**WEST SUSSEX COUNTY COUNCIL
FLOOD RISK MANAGEMENT CONSULTATION**

PLANNING REFERENCE: A/36/18/OUT

LOCATION: Land Off, Arundel Road, Angmering, BN16 4ET

Figure 5.2: Illustrative Masterplan.

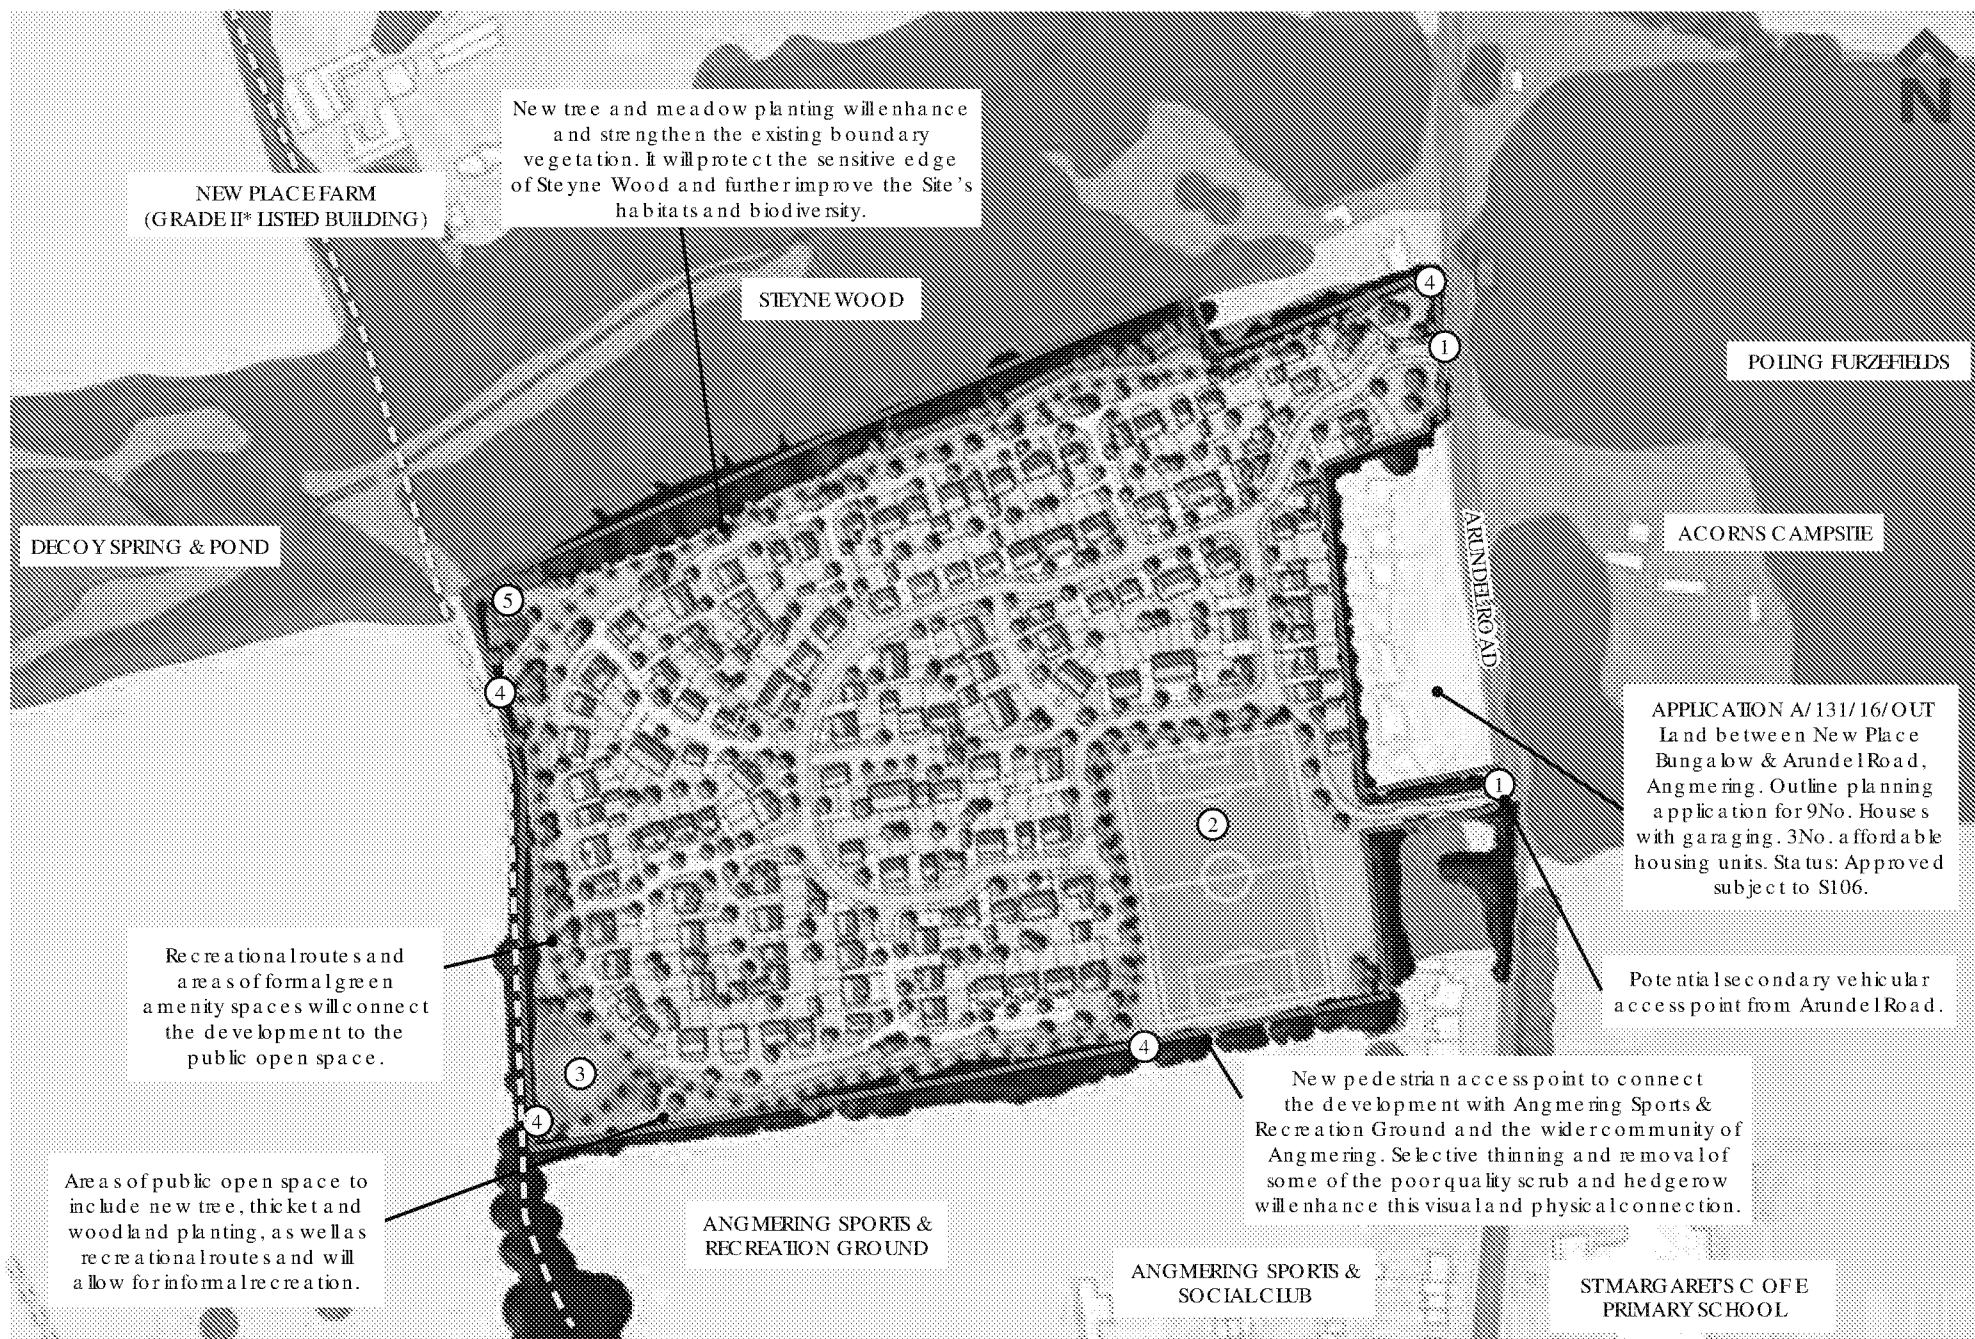
The current design suggests that a surface water pumping station would be installed on site. Clear evidence should be provided as to the need for a pumped surface water station as this is not a sustainable solution and should only be considered if all other options can be discounted.
